23/03925/REG3

Address: Goole Market Hall Estcourt Terrace Goole East Riding Of Yorkshire DN14 5AB

Proposal: Erection of sub-station, switch room, bin store and associated landscaping to existing yard, new roof covering and replacement roof lanterns

Name: . Building Conservation

PLANNING			
Client East Riding of Yorkshire Council			
Project Title Goole Market Hall			
Drawing Name Existing - Roof Plan			
Drawing No. GMH-GGA-01-ZZ-DR-A-2003			
Drawn	Project No.	Scale	Rev
SM	145		@A2 P02

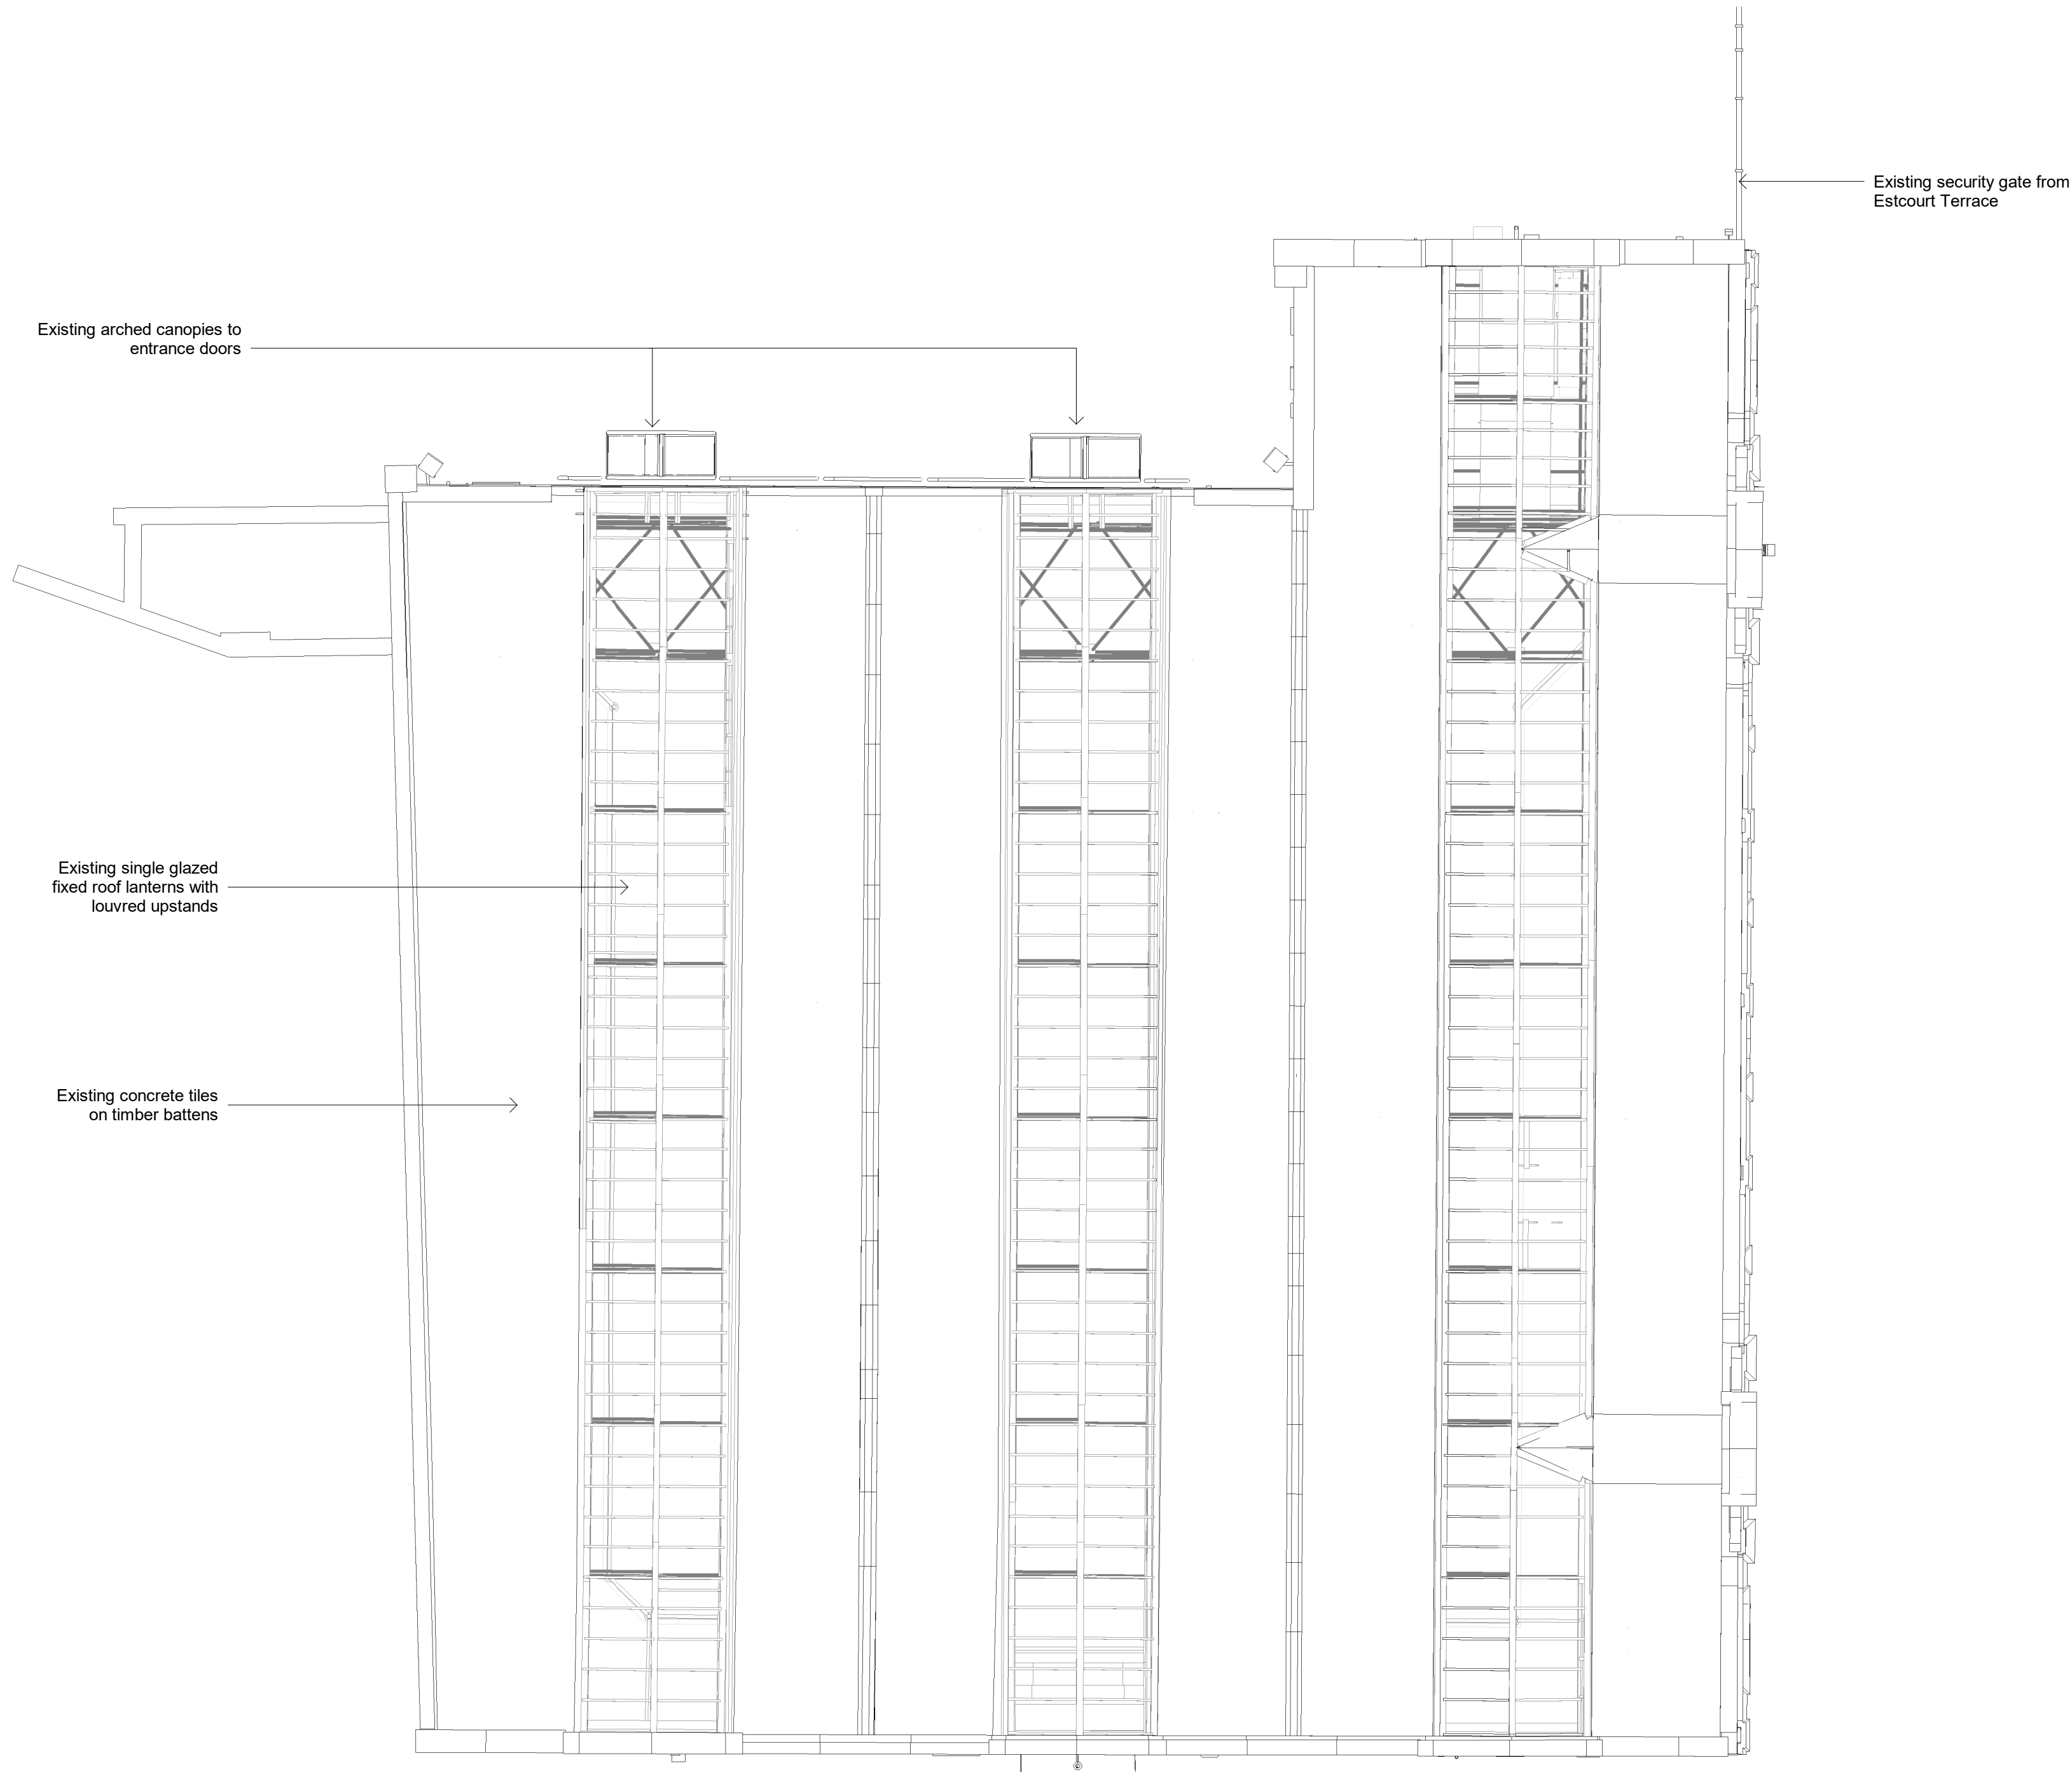
Considering the roof covering of concrete tiles is not original, and is not visible from the main public highway, there are no concerns with its replacement with light weight fibre cement tiling. The proposed material is little different to the existing and would be unlikely to impact the

character and appearance of the conservation area. In relation to the existing single glazed roof lanterns, they are a unique feature for the Market Hall. Whilst it would be a shame to lose the historical value that single glazing contributes to the special interest of the Market Hall, it is understood from a perspective of trying to improve energy efficiency that replacing with double glazing would increase the likelihood of the space being able to be used comfortably. The removal of the mid-late 20th century decorative market stalls would impact the historical and evidential value of the building; however the original steelwork is to be retained as existing which is positive. The harm caused through the loss of the later additions is considered to be outweighed by the benefit of the building being brought back into beneficial use.

<b>PLANNING</b>			
Client: East Riding of Yorkshire Council			
Project Title: Goole Market Hall			
Drawing Name: Proposed -Block Plan			
Drawing No.: GMH-GGA-01-ZZ-DR-A-2100			
Drawn	Project No.	Scale	Rev
SM	145	1 : 200	@A2 P02

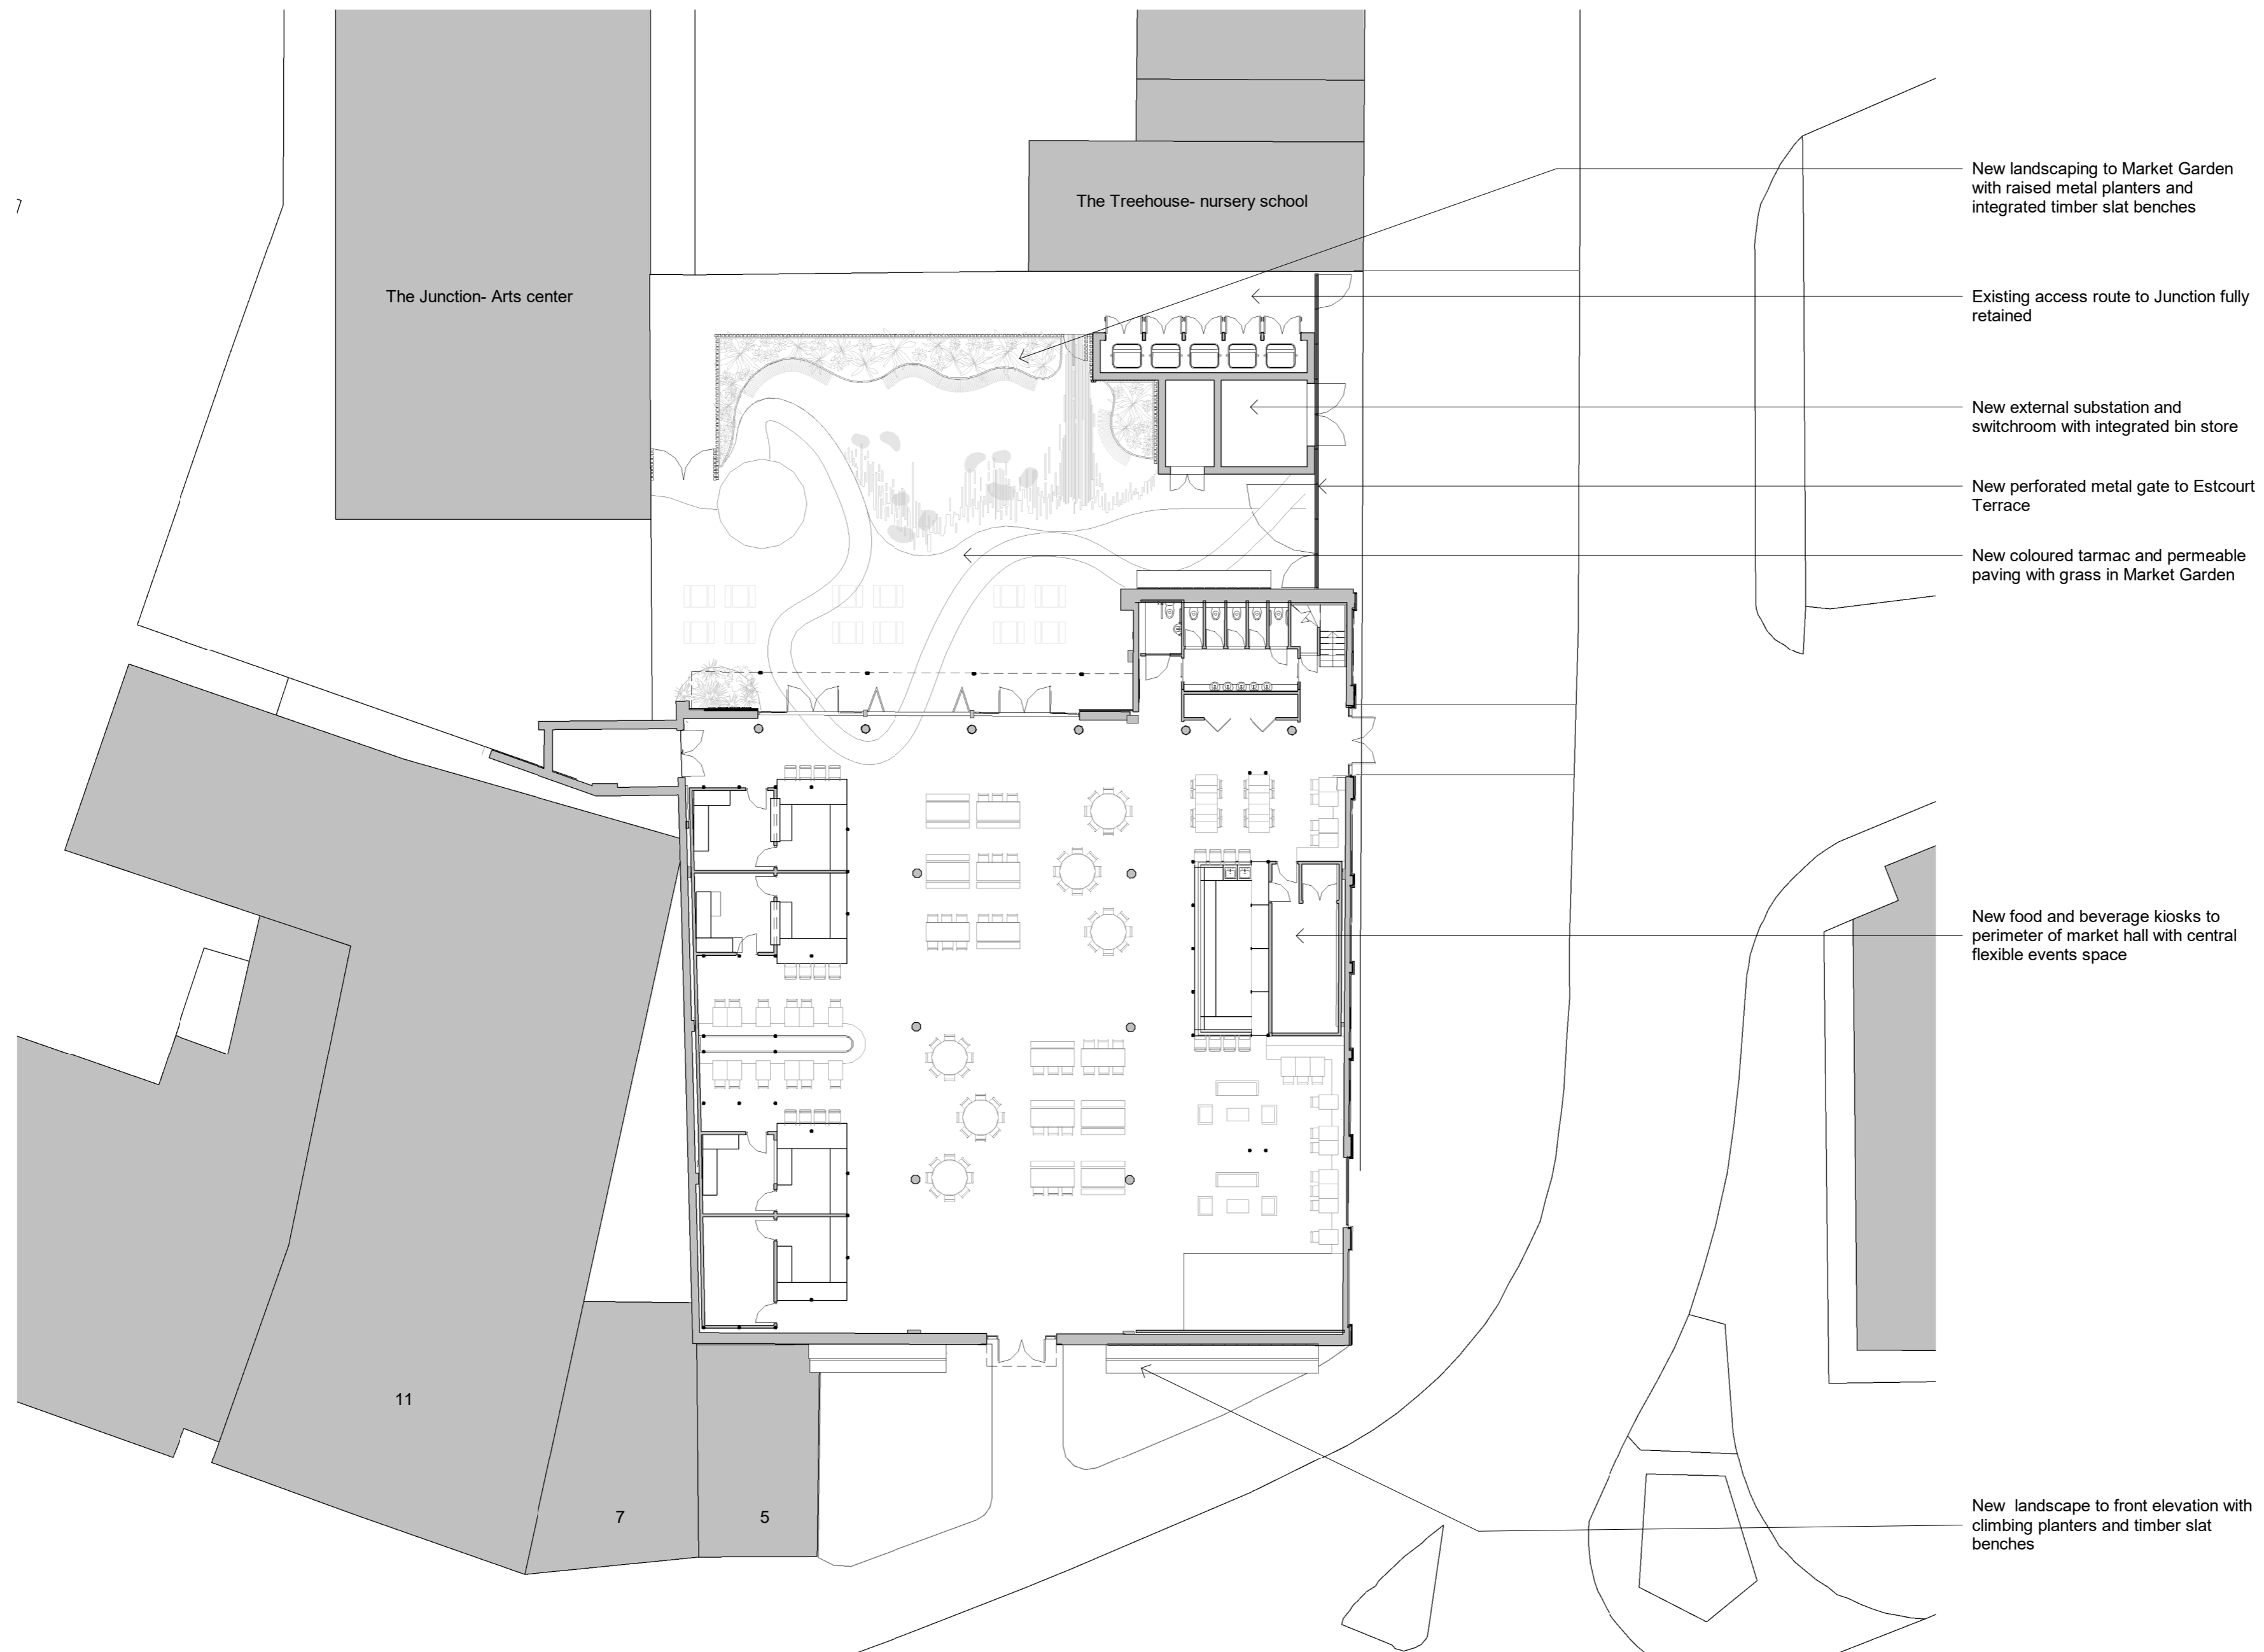
There are no concerns with the erection of a substation, switch room and bin store or the associated landscaping to the existing yard. The proposed landscaping would enhance this part of the conservation area. The proposals for the north elevation including replacing glazing to the ground floor, installing polycarbonate cladding to the first floor and erecting a metal canopy is supported. The north elevation is not the principal elevation and has already been altered as evident from the existing large area of glazing. The proposal for this elevation would be unlikely to alter the level of harm caused to the character and appearance of the conservation area.

PLANNING			
Client East Riding of Yorkshire Council			
Project Title Goole Market Hall			
Drawing Name Proposed - Elevations 02			
Drawing No. GMH-GGA-01-ZZ-DR-A-2105			
Drawn	Project No.	Scale	Rev
SM	145	1 : 1000	@A2

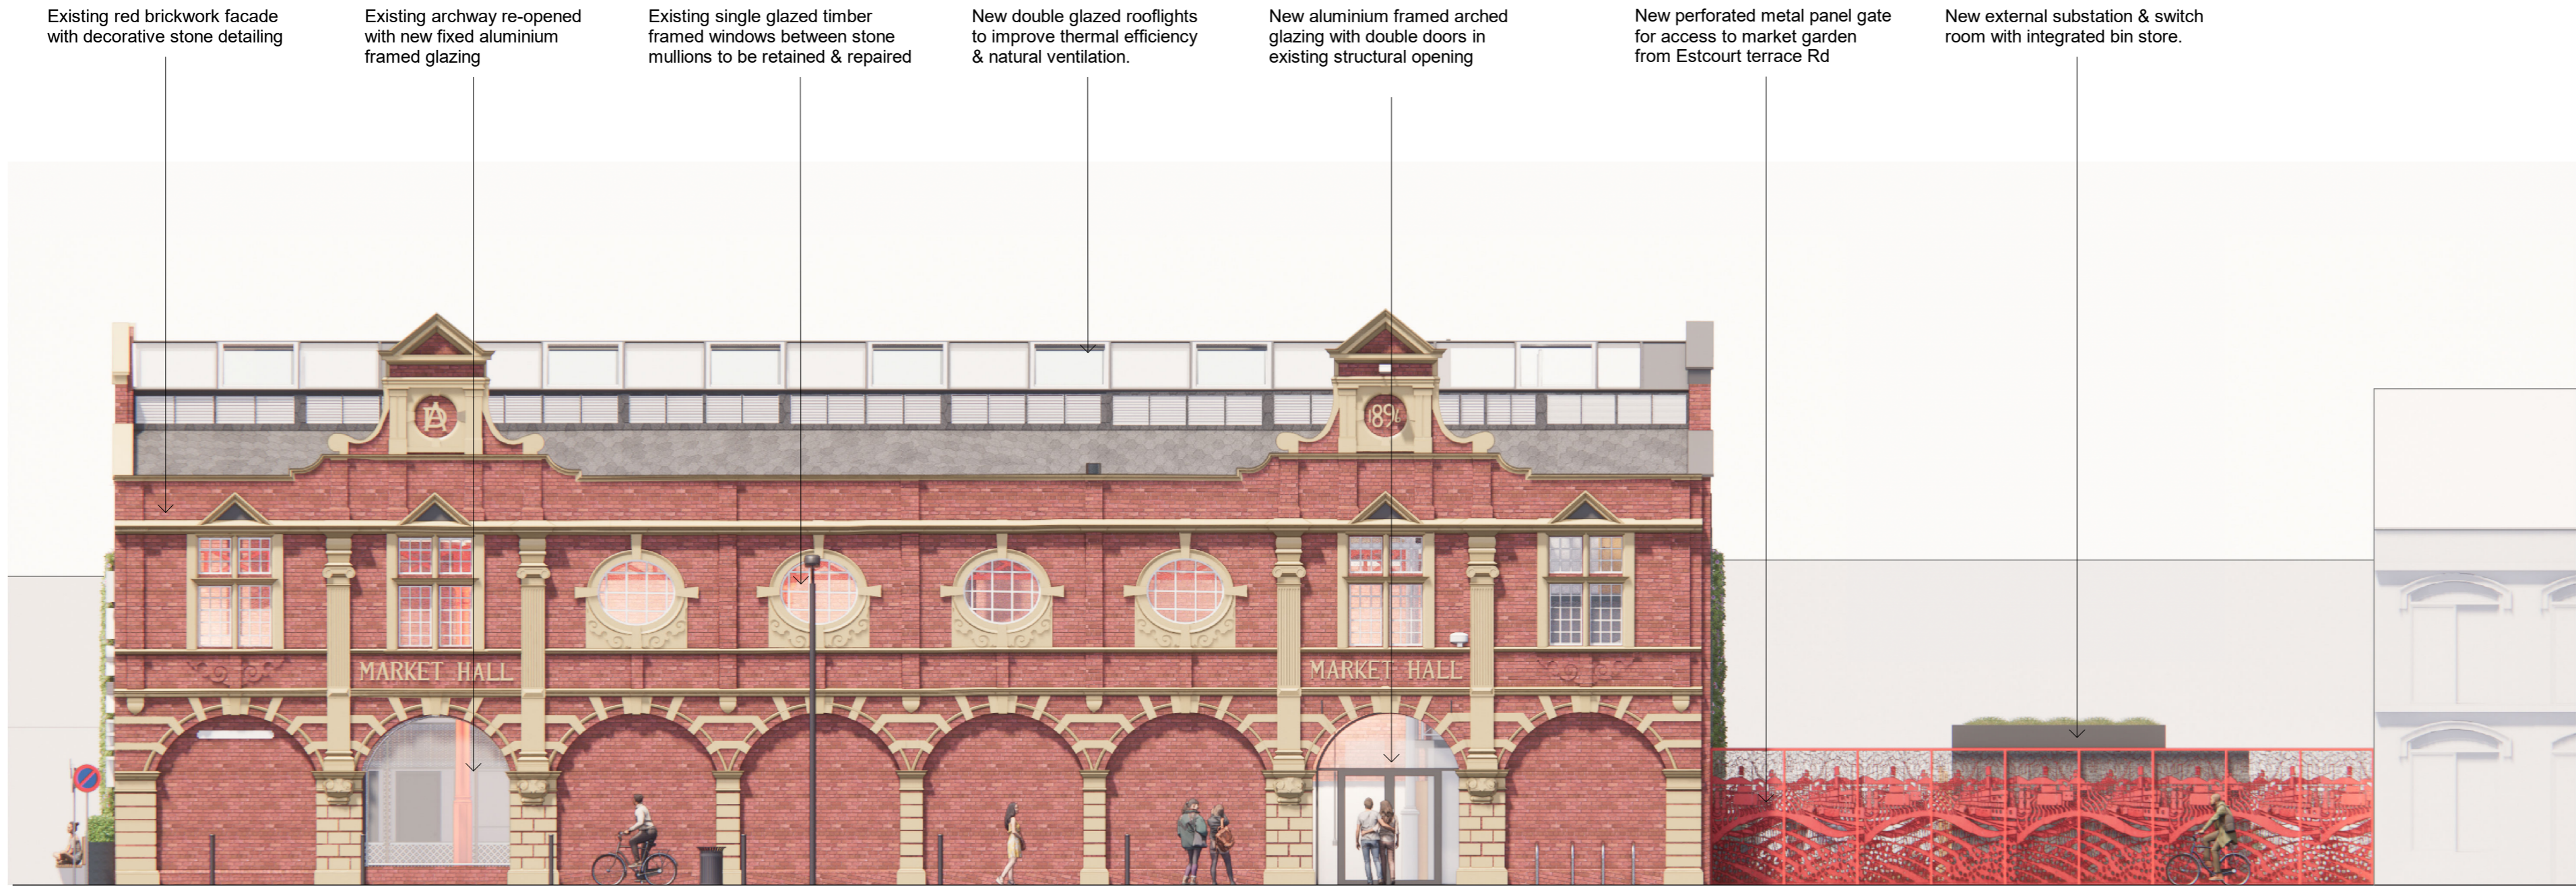
Reopening an existing blocked over entrance on the east elevation is positive. This elevation holds the most interest historically and aesthetically. The retention of the original windows to the first floor combined with re-opening an entrance would enhance this part of the conservation area. There are no concerns with the proposal for the south elevation as little is changing.
